WELWYN HATFIELD COUNCIL – DEVELOPMENT CONTROL
DELEGATED REPORT

APPLICATION No:	S6/2011/1397/FP
------------------------	------------------------

The proposed development would involve an extension to the northern flank wall of the dwelling. The proposal would measure 7.74m in depth by 2.86m in width and would adjoin the main roof to create a gable end with a new chimney. The application also involves the demolition of a garage to reduce some of the built development within the application site.

TITLE OF DRAWING  
**Existing & Proposed Blockplan**

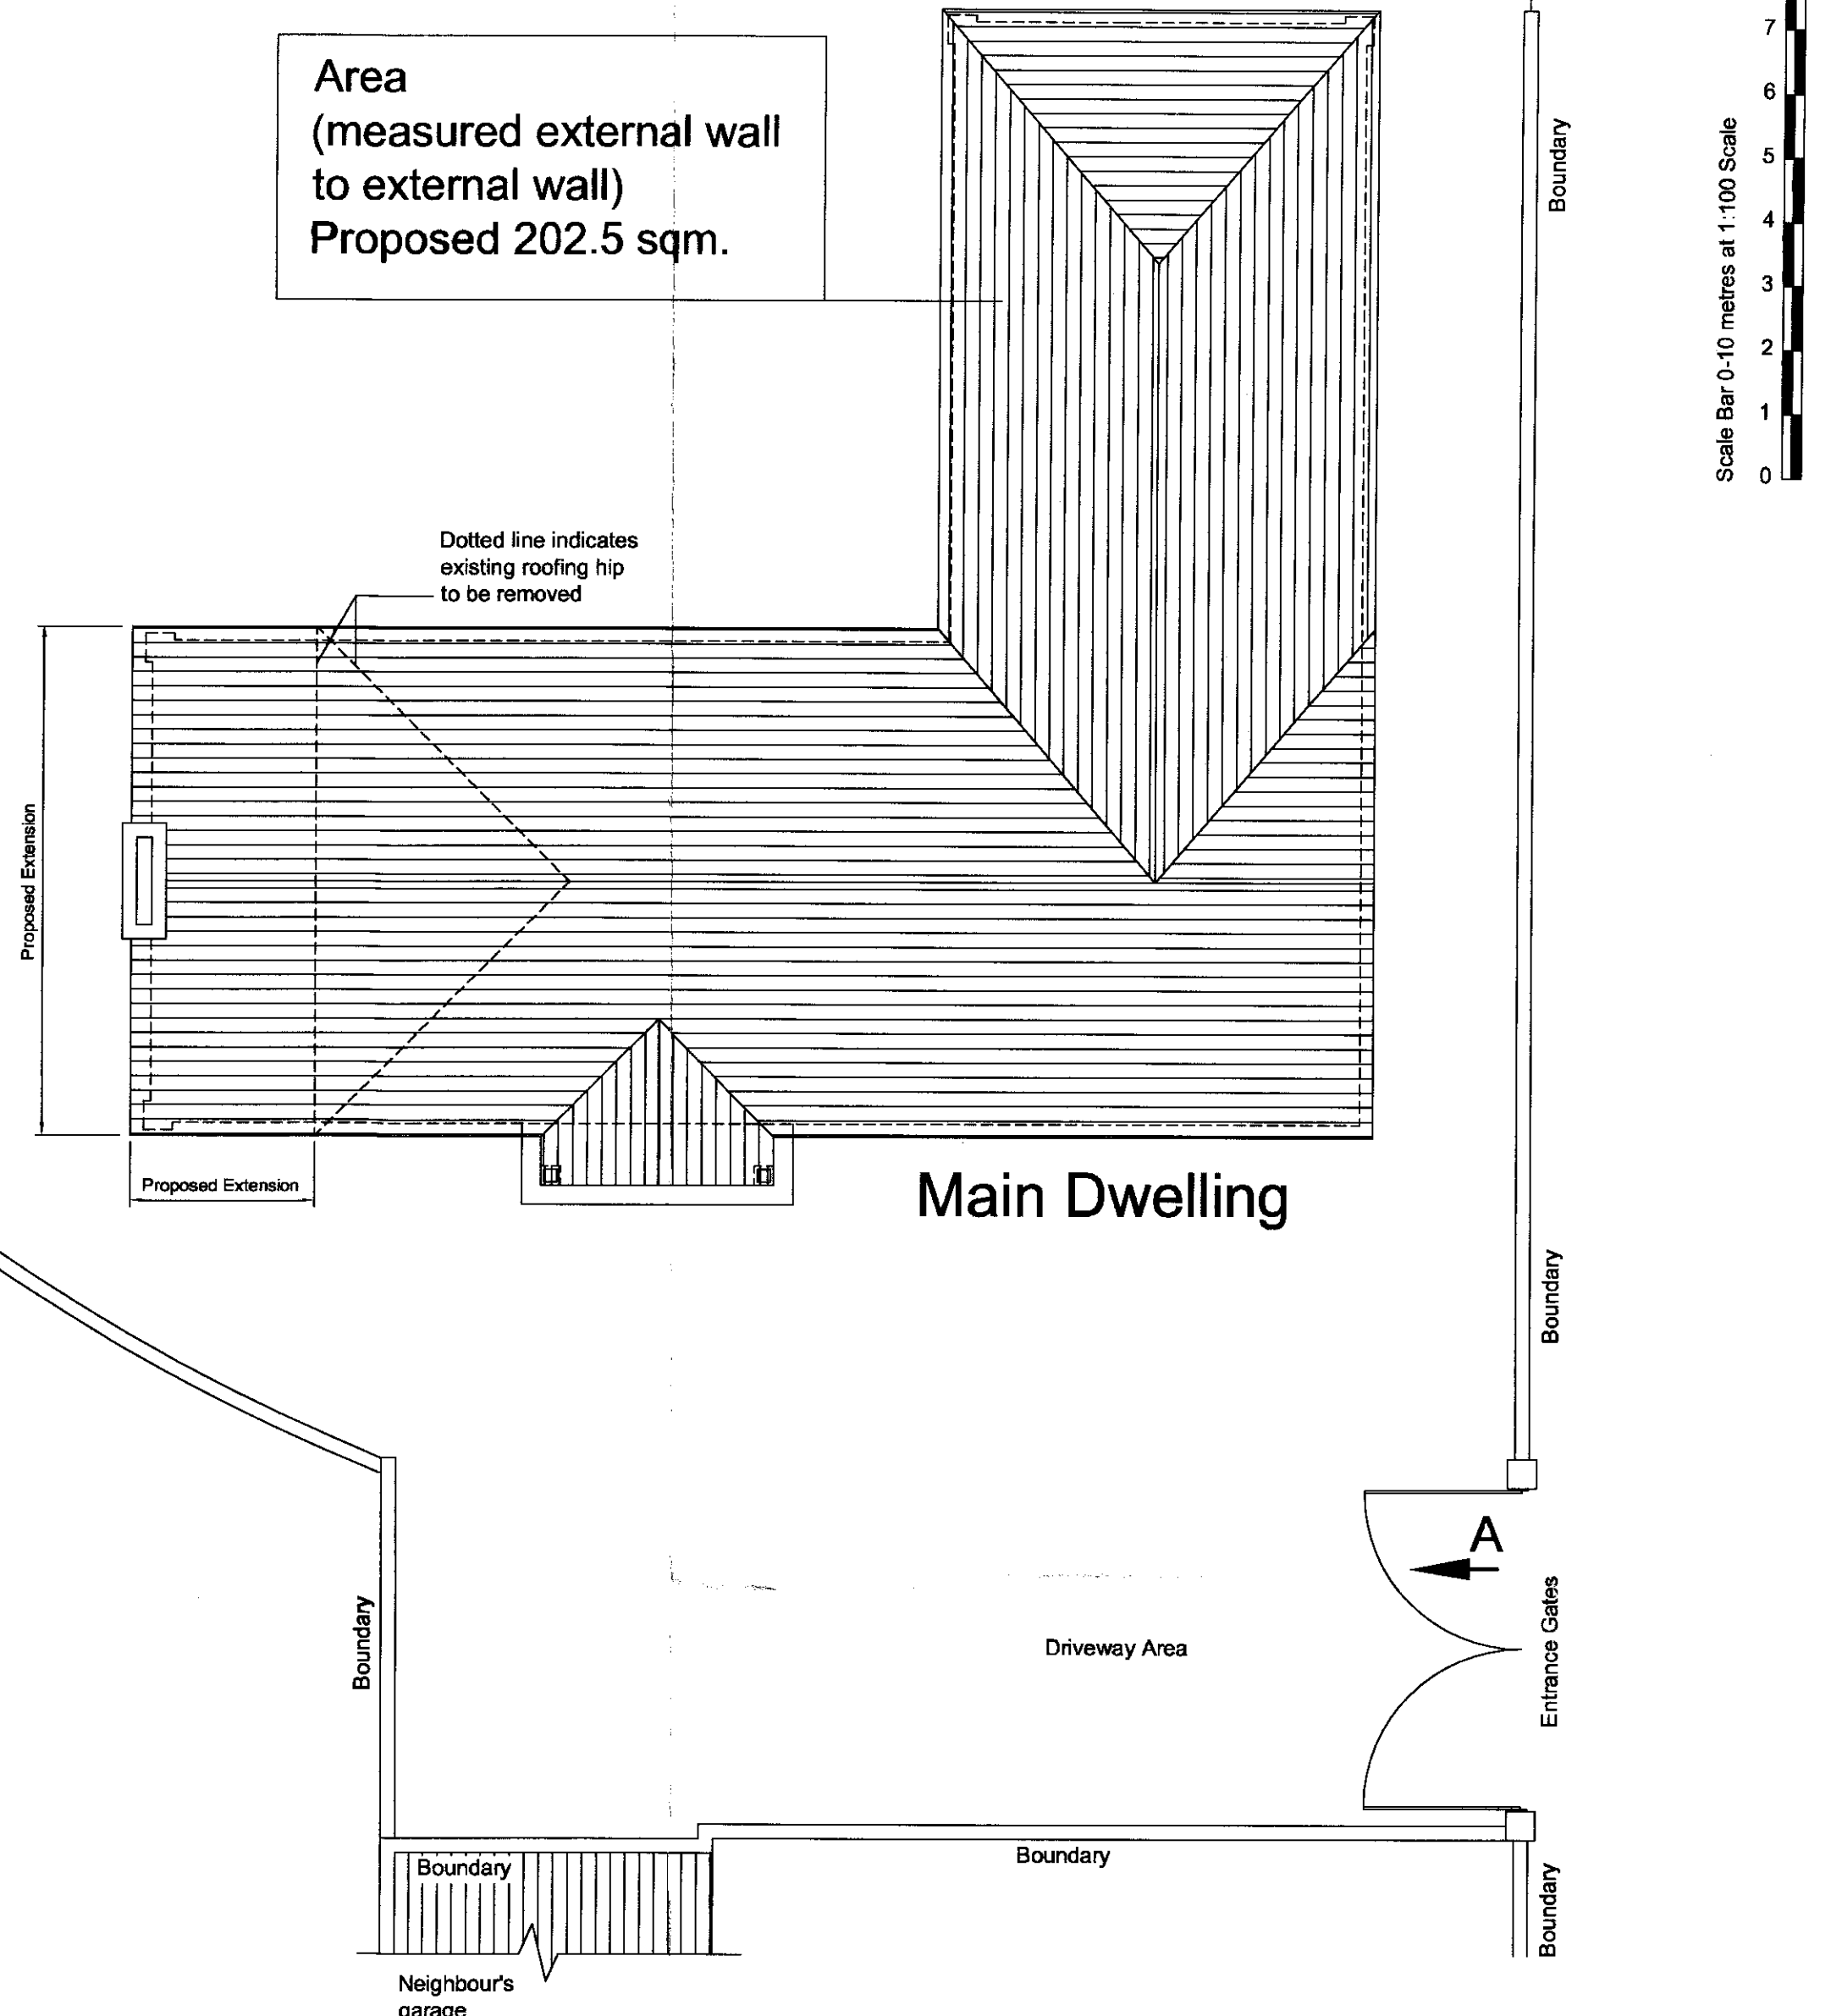
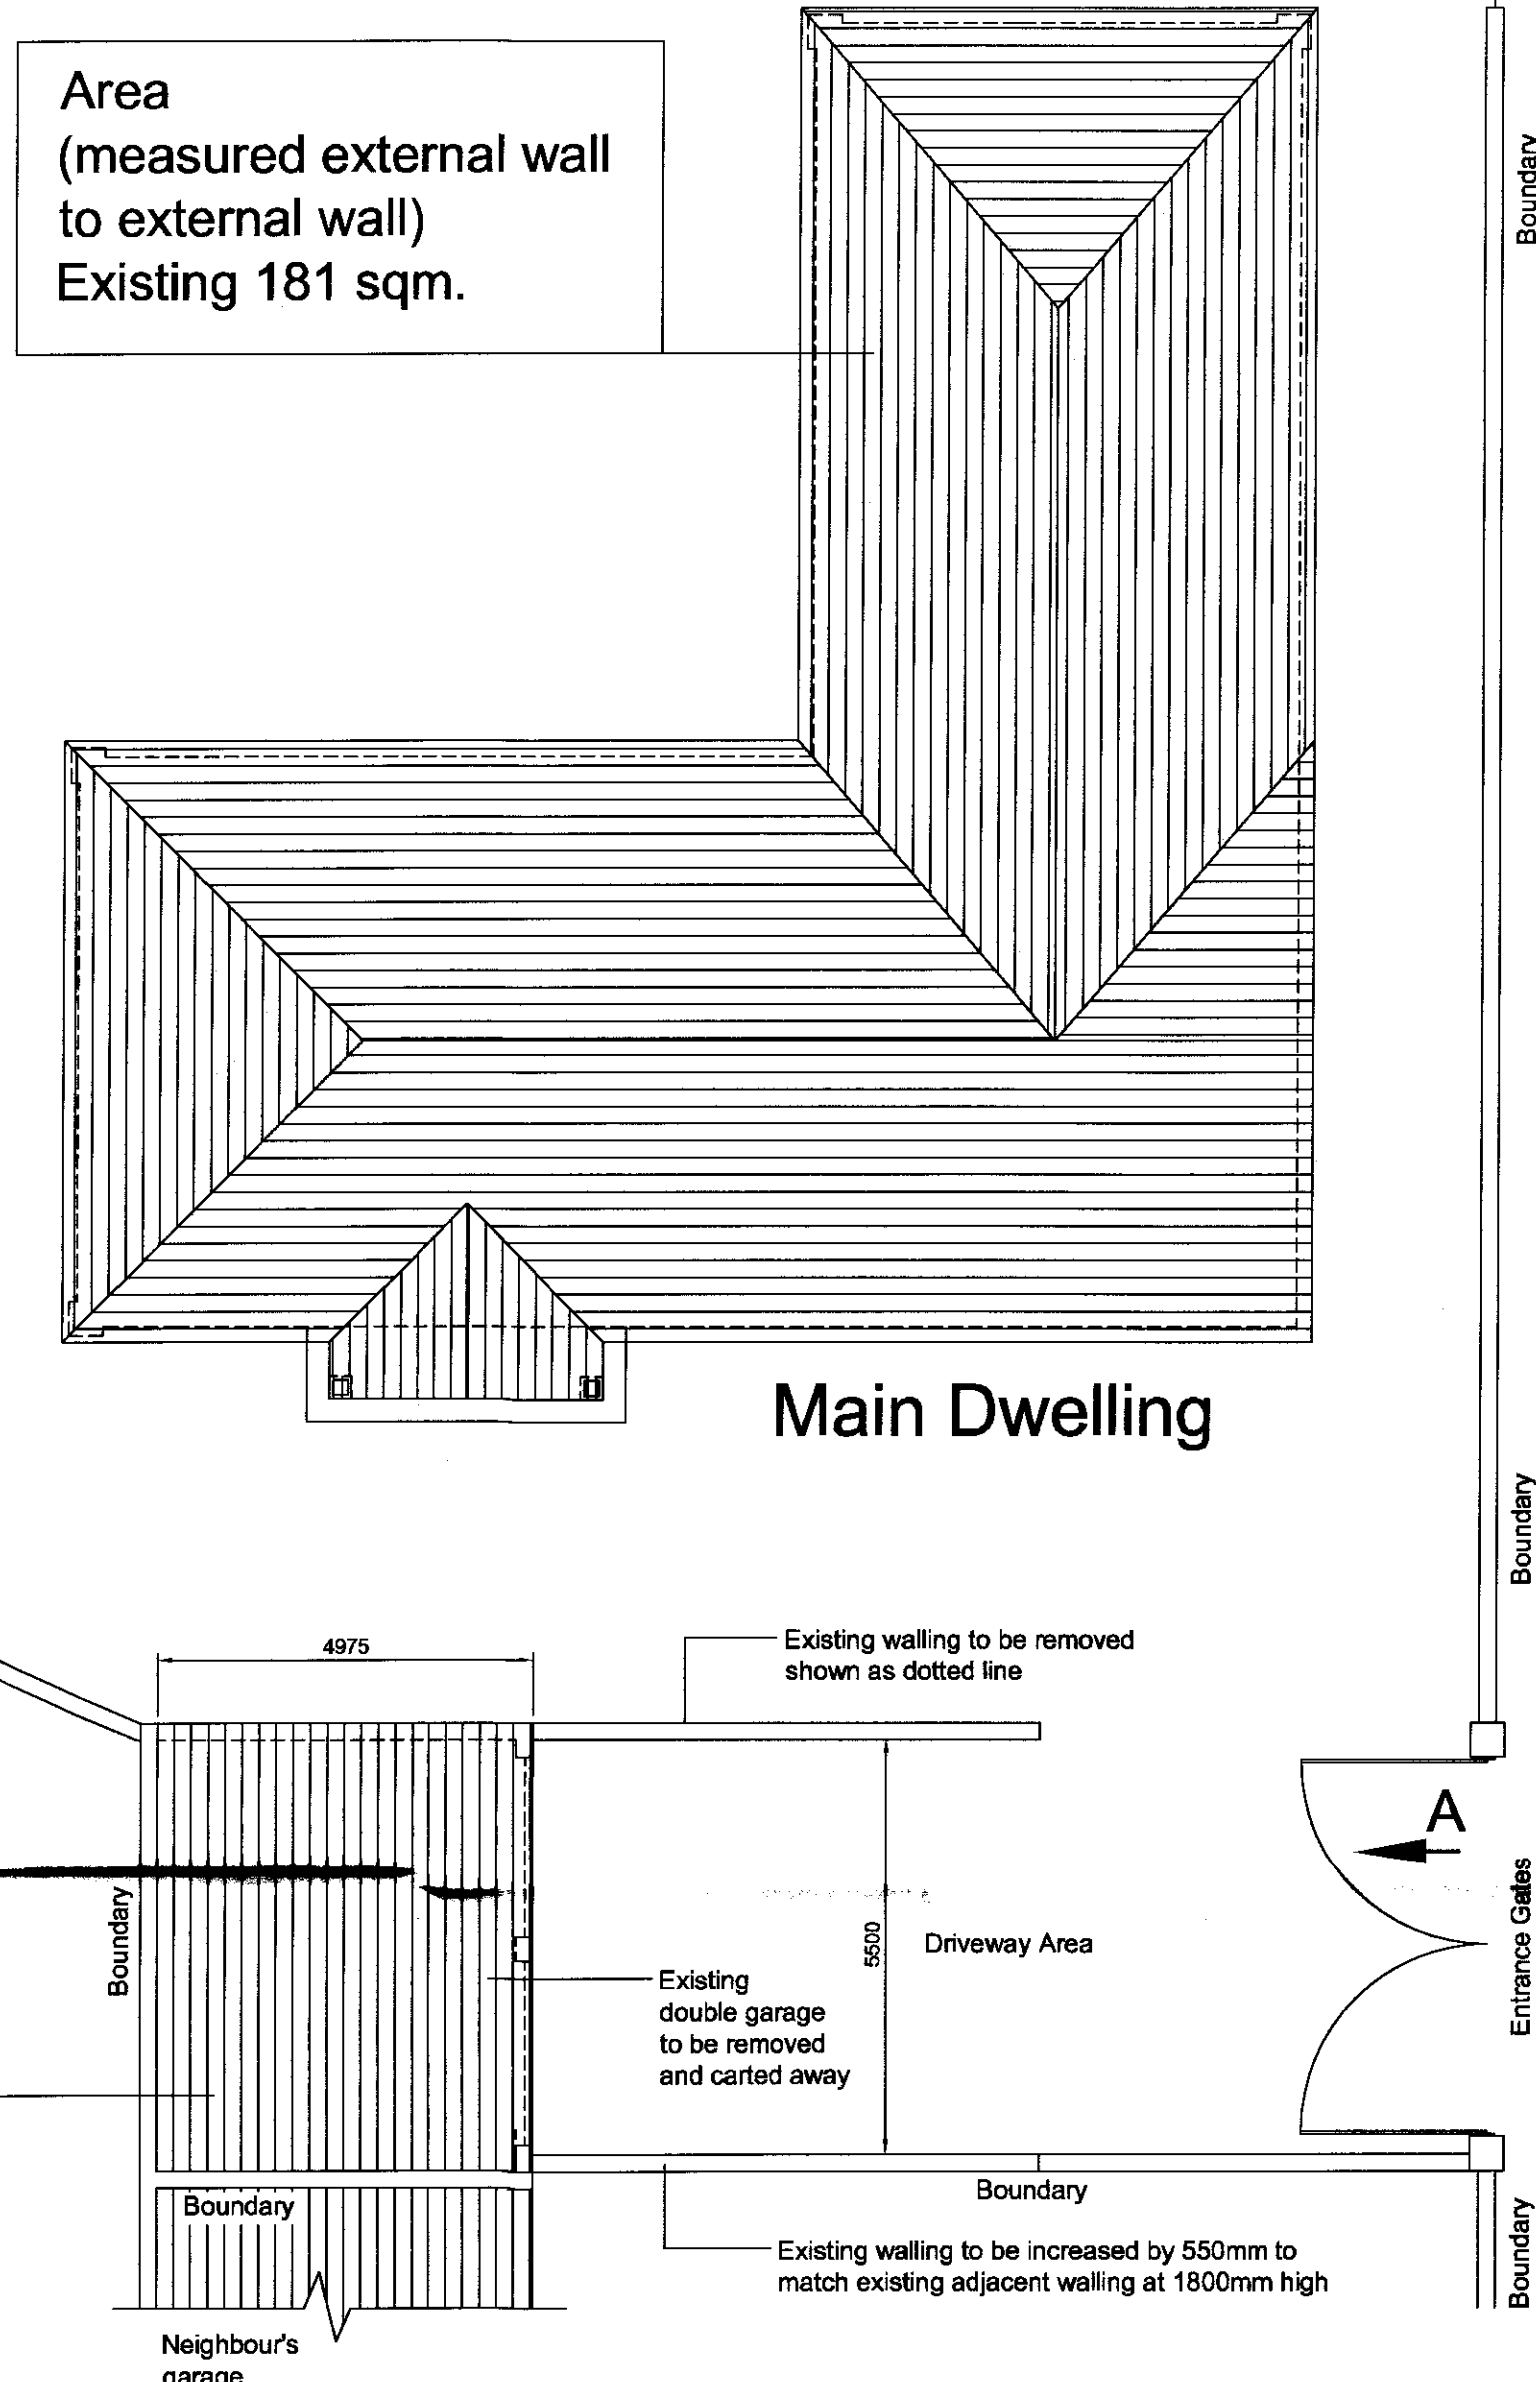
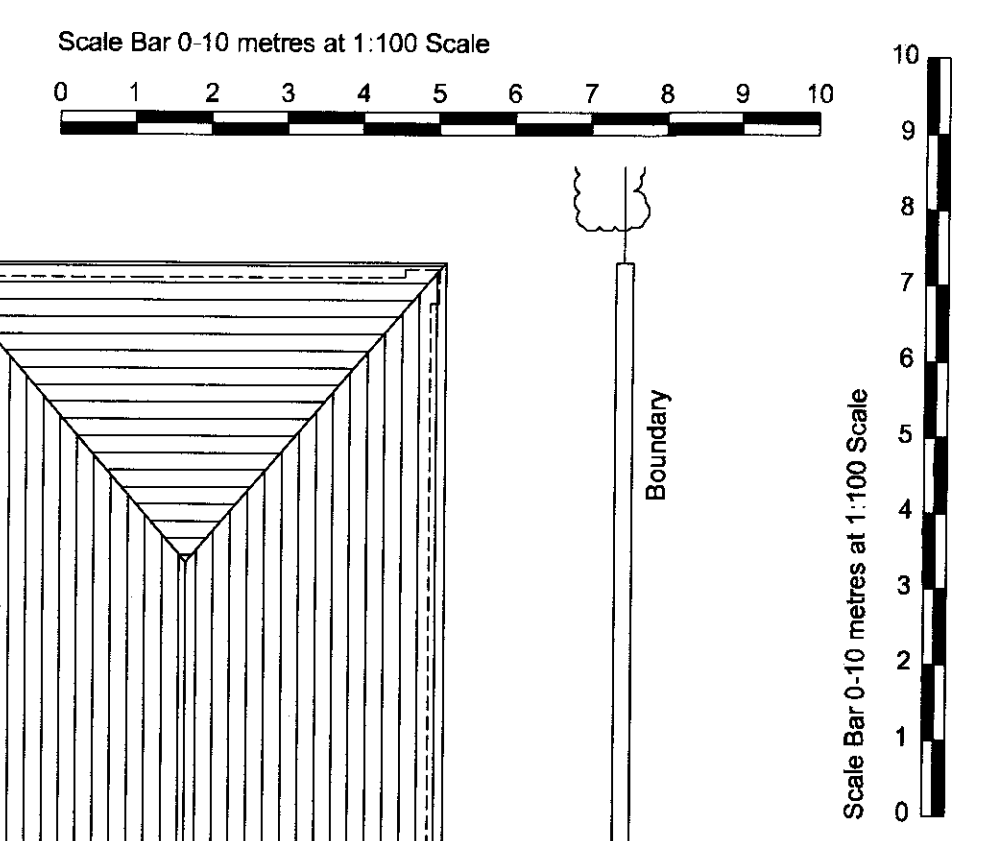
The applicant has proposed to demolish an existing garage, which would remove some of the built development within the plot. This reduction would be an attempt to offset the additional bulk and massing of the proposal.

Although this garage has not been taken into account in the calculations of the dwelling's floorspace and it does not form a habitable area, it does add to the bulk and massing of development within the plot. The existing garage has a larger floorspace (29.6m²) than the proposed extension, however, the roofspace and gable end of the proposal would give it a bulky appearance. The garage has an ancillary appearance to the main dwelling, but spreads development within the plot. If removed the openness between the application dwelling and the adjacent dwelling to the west (the barn) would be increased.

1. C.2.1: Standard Time Limit
2. C.13.1: Development in accordance with approved plans/details Site Location Plan 1:1250 & PL2000 & PL3000 received and dated 27 July 2011.
3. Prior to construction of the extension hereby permitted, the existing double garage to the western side of the site shall be demolished and all the materials

arising from such demolition shall be completely removed from the site in accordance with drawing PL-3000 received and dated 27 July 2011.
